Beaches Link and Gore Hill Freeway Connection (SSI 8862) – Advice on Environmental Impact Statement (EIS)

Thank you for inviting the Heritage Council of NSW to provide advice on the Beaches Link and Gore Hill Freeway Connection project. The Council notes the city-shaping nature of this critical infrastructure project. To maximise heritage management outcomes, Heritage NSW, as delegate of the Heritage Council, provides the following response.

4 March 2021

Figure 14-1 Location of terrestrial heritage items impacted by the project

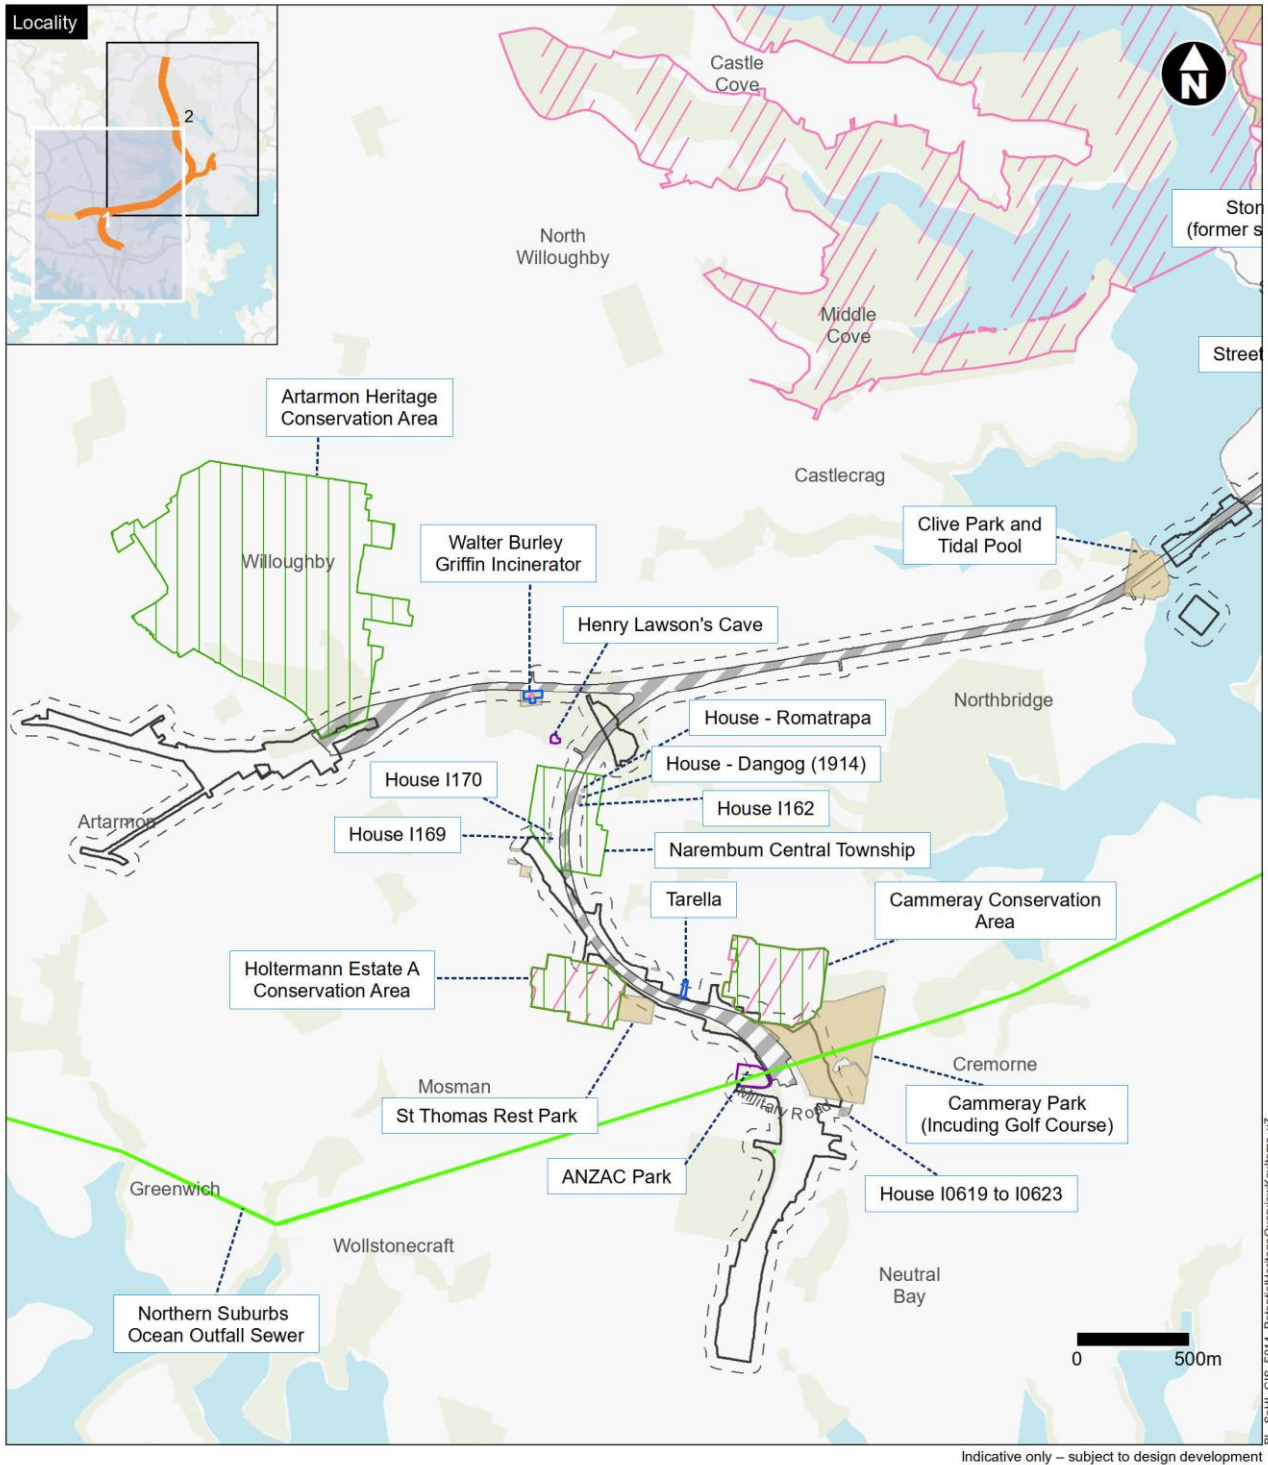
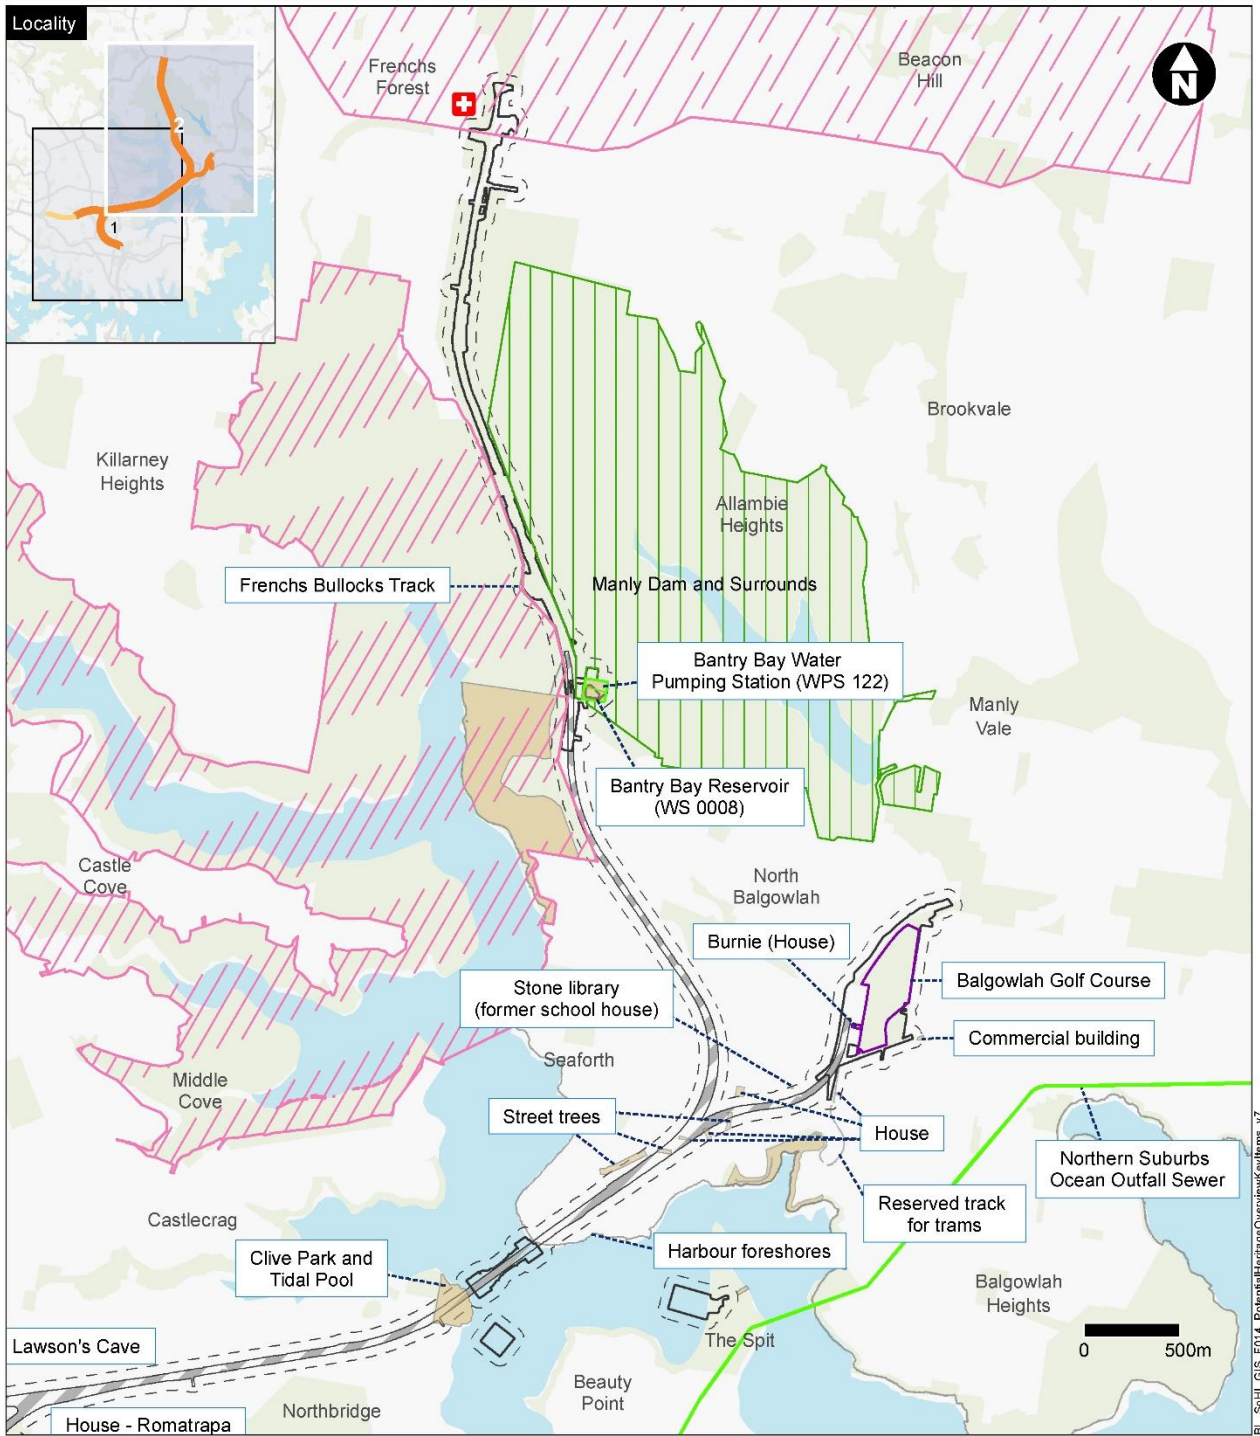
Environment management measure **SG7** recommends minimum working distances to avoid “cosmetic and structural damage due to vibration”. We recommend that Environment management measure **NAH10 (and other relevant NAHs)** should have an aim to prevent

both cosmetic and structural damage - and not just to prevent cosmetic damage of heritage items such as to Tarella and Walter Burley Griffin Incinerator.

Environment management measure **CNV7** recommends a “more detailed assessment will specifically consider the heritage values of the structure [heritage items] as part of the management of construction vibration impacts. We recommend that the assessment should also include the three potential non-Aboriginal terrestrial heritage items, and not just already listed heritage items.

- Construction and operation of the Beaches Link and Gore Hill Freeway Connection project should aim not to diminish the **potential for listing as heritage items** in relevant Local Environmental Plans, of Balgowlah Golf Course, Henry Lawson's Cave, and ANZAC Park.

Figure 14-3 Location of maritime heritage items impacted by the project

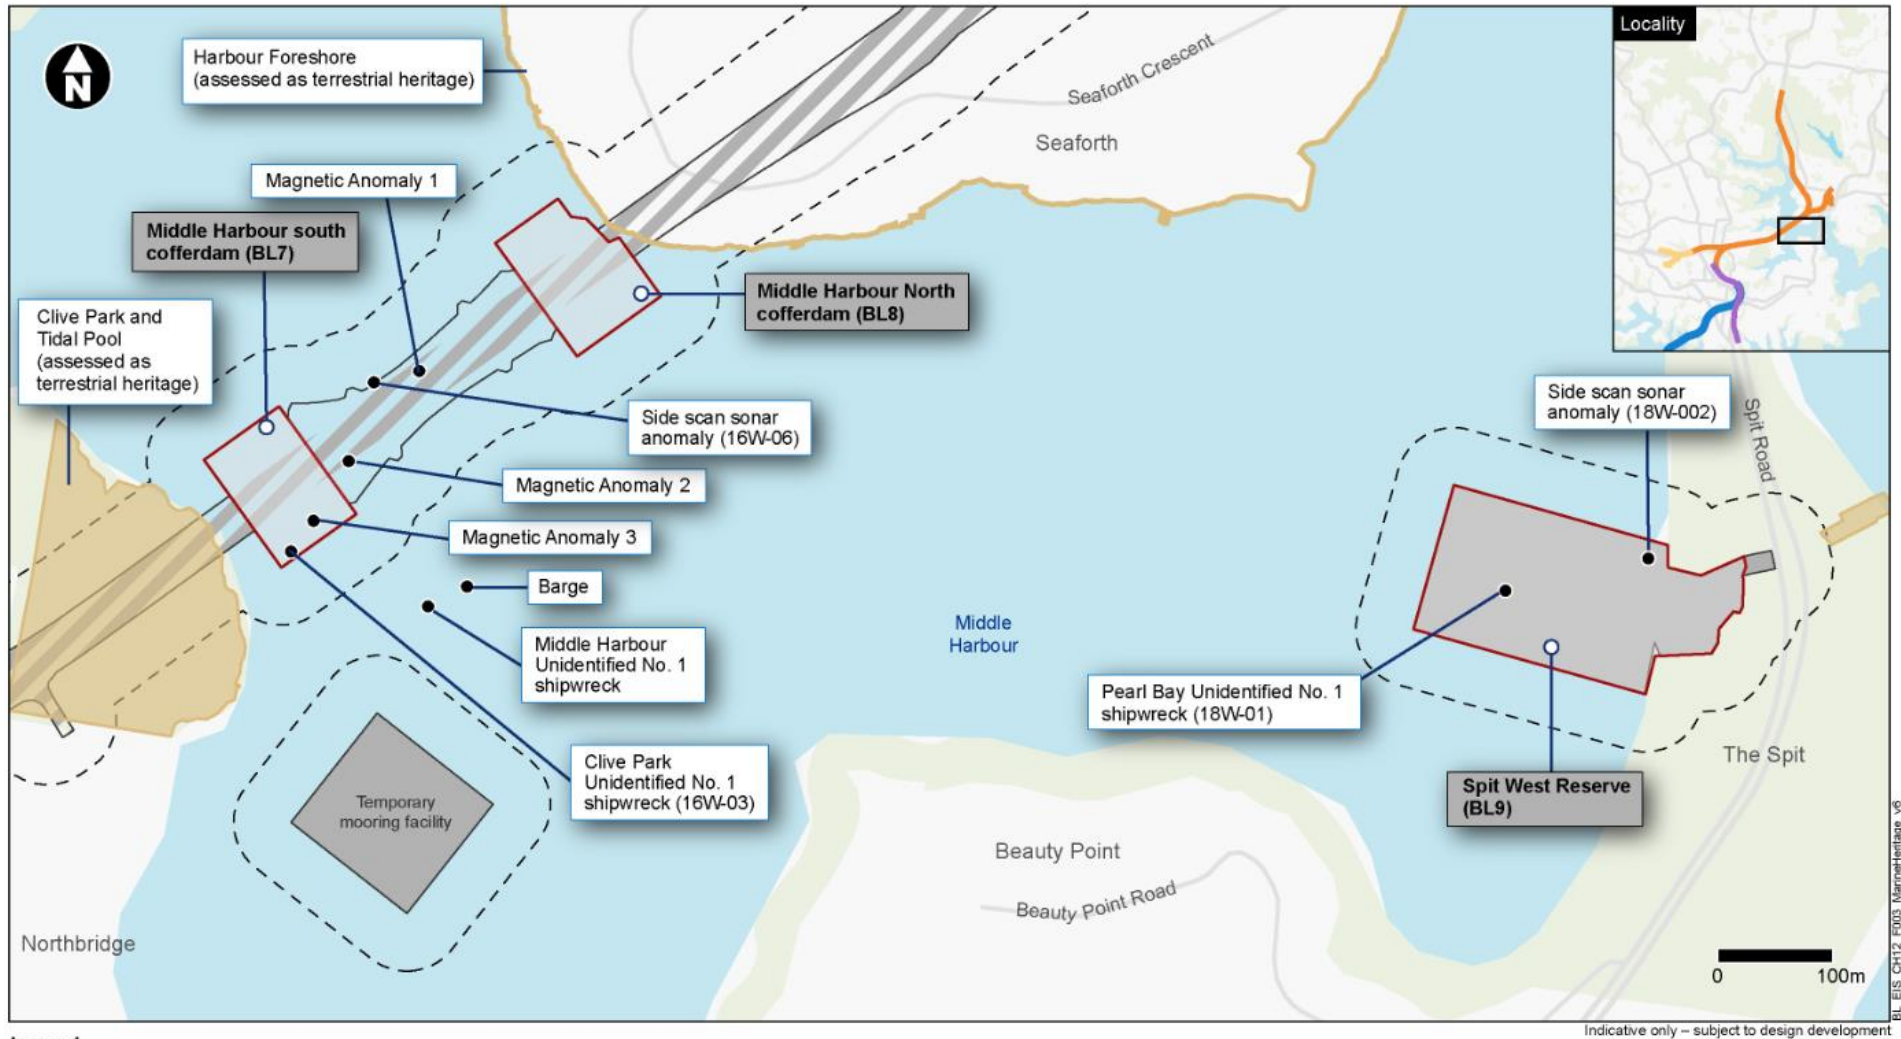
One of these sites is likely to be directly impacted by the proposed dredging for the new tunnel installation (Unidentified Middle Harbour Clive Park #1).

Heritage NSW as delegate of the Heritage Council, supports these mitigation conditions but notes that the EIS is yet to assess the potential affects (if any) of slumping on the known and previously unidentified/ undiscovered heritage sites that may exist within the proposed works area.

We identify that further work is required to determine the effects and possible extent of slumping associated with dredging in these areas (if any), and this should provide additional courses of action in the Maritime Heritage Management Plan which address any threats to known and potentially buried maritime heritage sites in slumping areas, and subsequent actions to manage, record, interpret and conserve any sites which may be exposed and/or subsequently threatened as a result of these works (see attachment).

- The project still needs to consider the effects (if any) of potential slumping associated with the dredging and caisson installation activities, especially for known archaeological/heritage sites within the development footprint, but also for currently known and potential previously unidentified sites outside this zone. Slumping is caused by the subsidence of silt/sand trenches and can have adverse effects for some distance from the activity dependent on the depth of the dredging. Any dredging works should be supervised by a suitably qualified and experienced maritime archaeologist and the **Unexpected Finds Policy** (see below) should be followed if previously unidentified or unknown sites are exposed during this work.
